Application no: H11/1088/99

Description: Installation of a liquid
petroleum gas (LPG) compound
including fencing and lighting

Location: Main Road Service Station
Wisbech Road
Long Sutton
Spalding Lincs

Amendment: Delete crash barrier and reduce extent of wall
Dwg. No. 1333570 Rev A

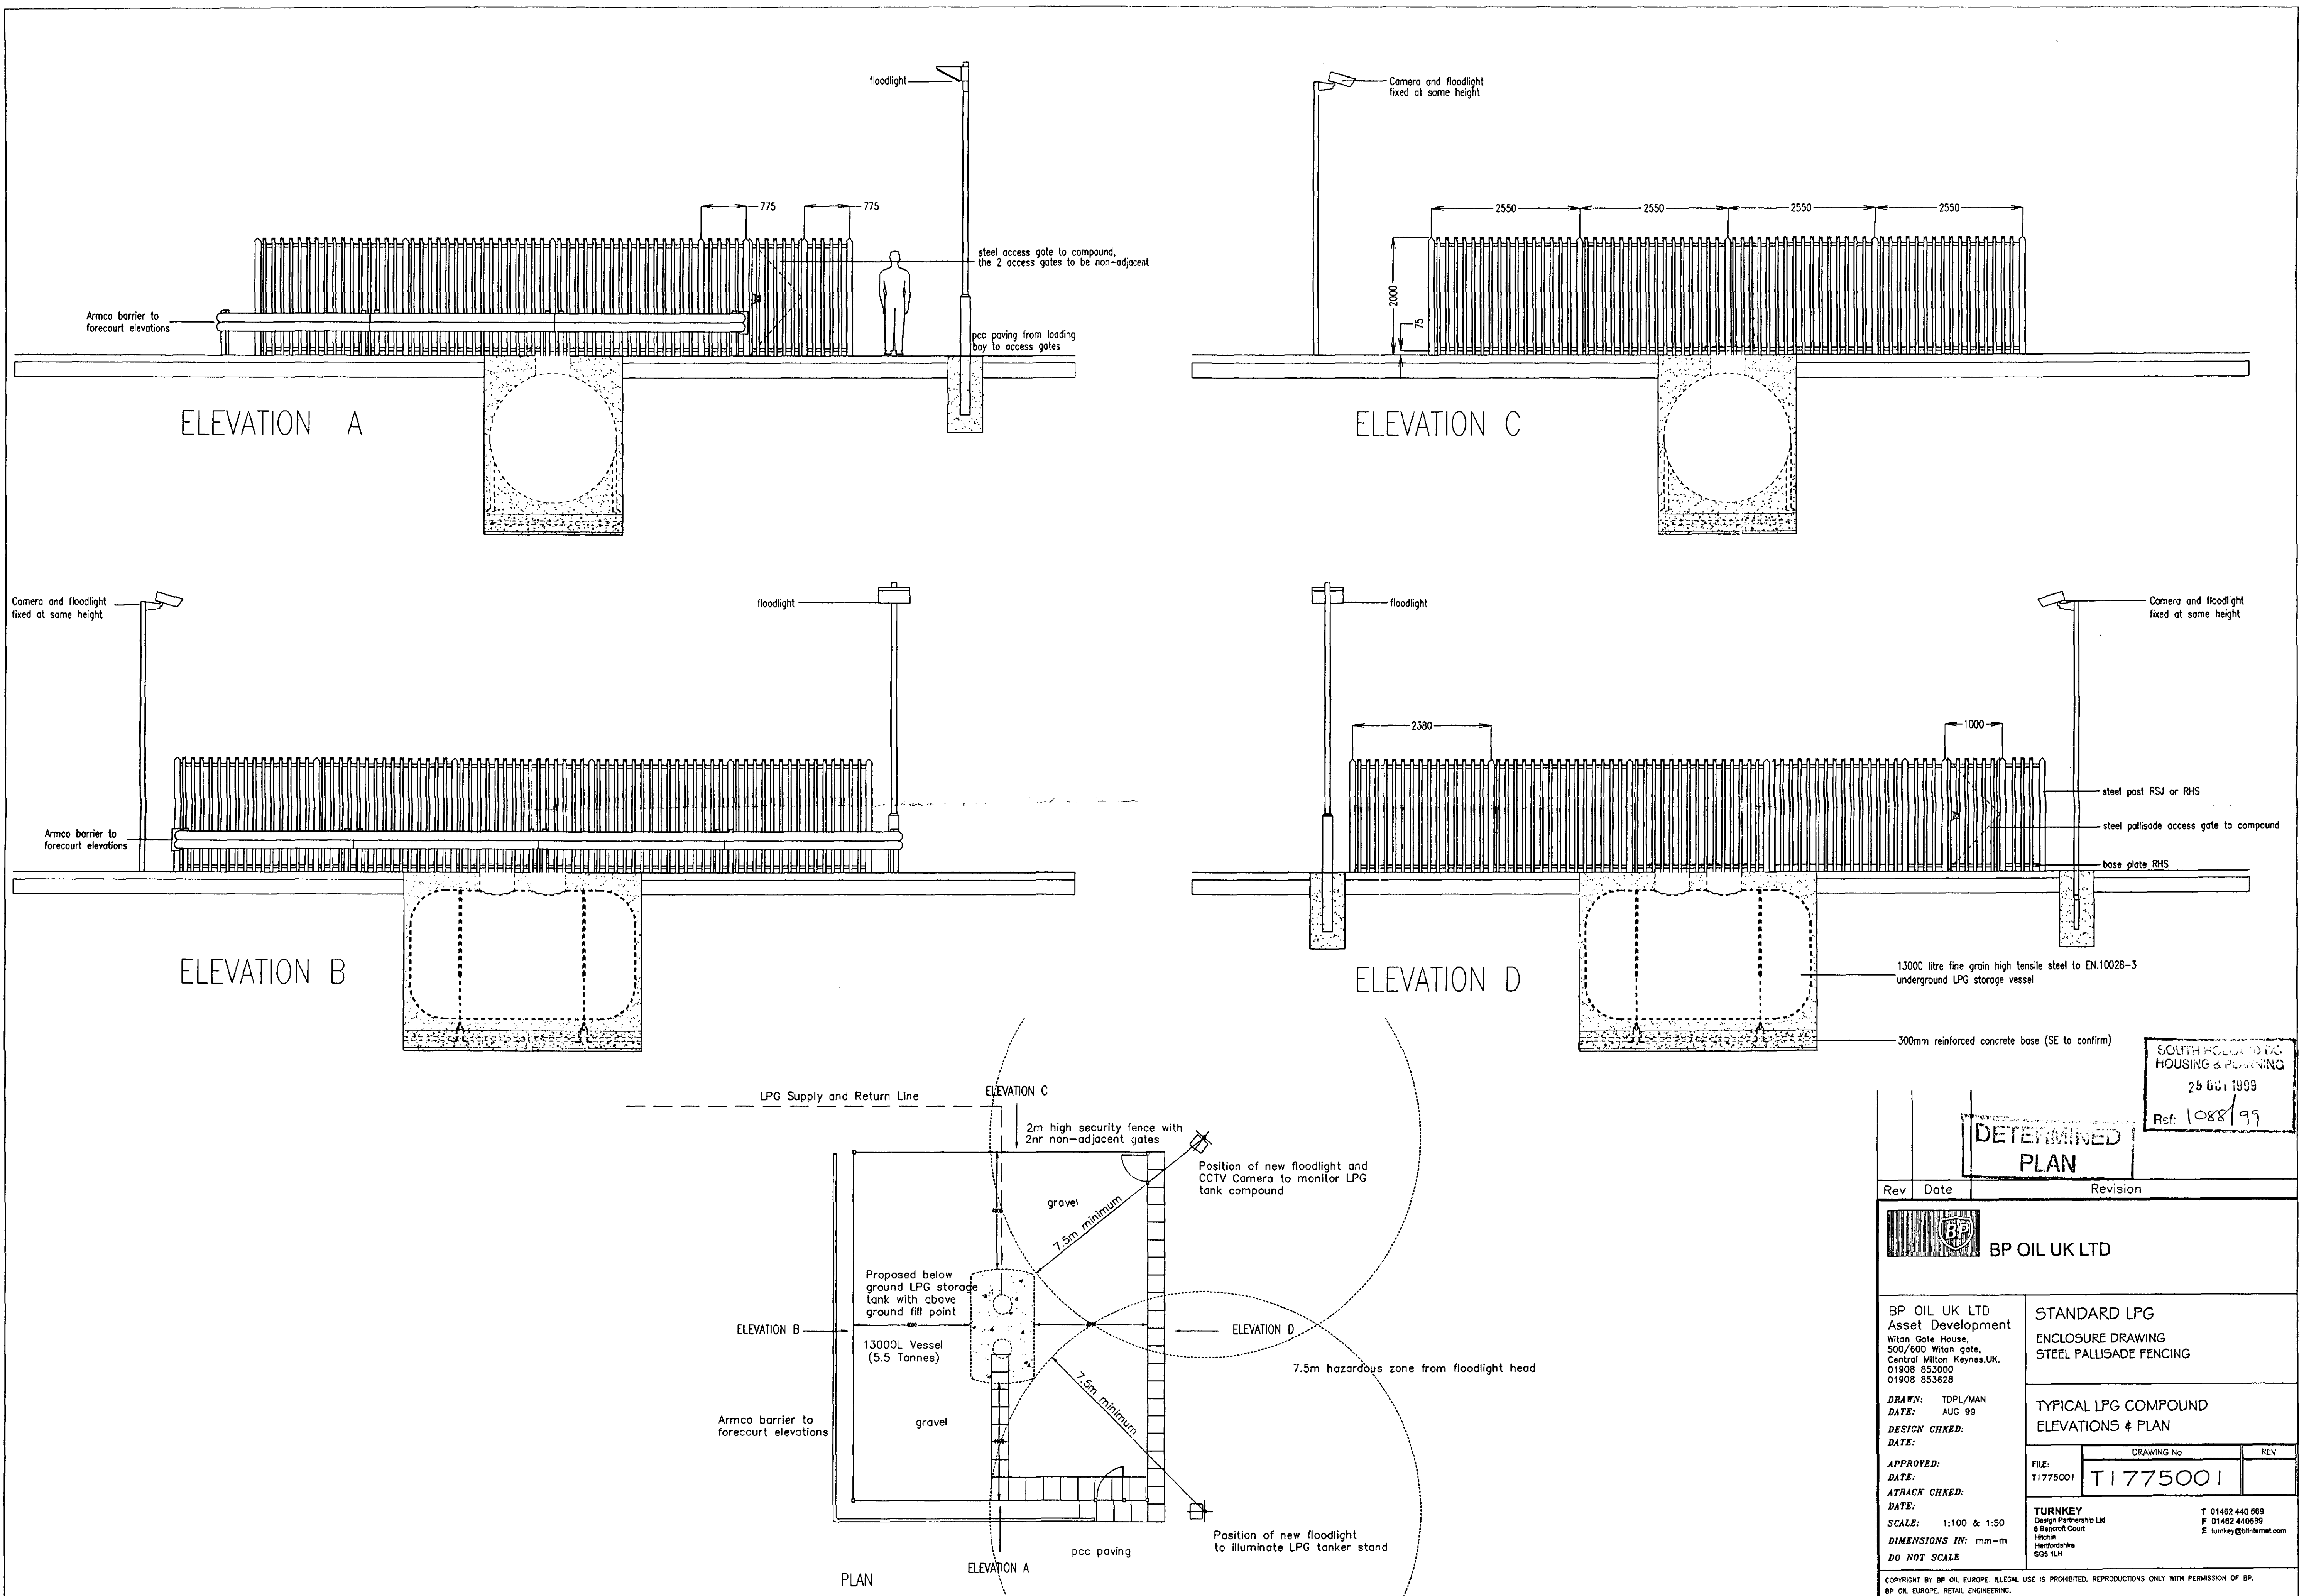
DELETE CRASH BARRIER
+ REDUCE EXTENT
OF WALL.

The amended details submitted in respect of the above proposal have now been considered and there are no objections to the amendment being implemented to the extent described above.
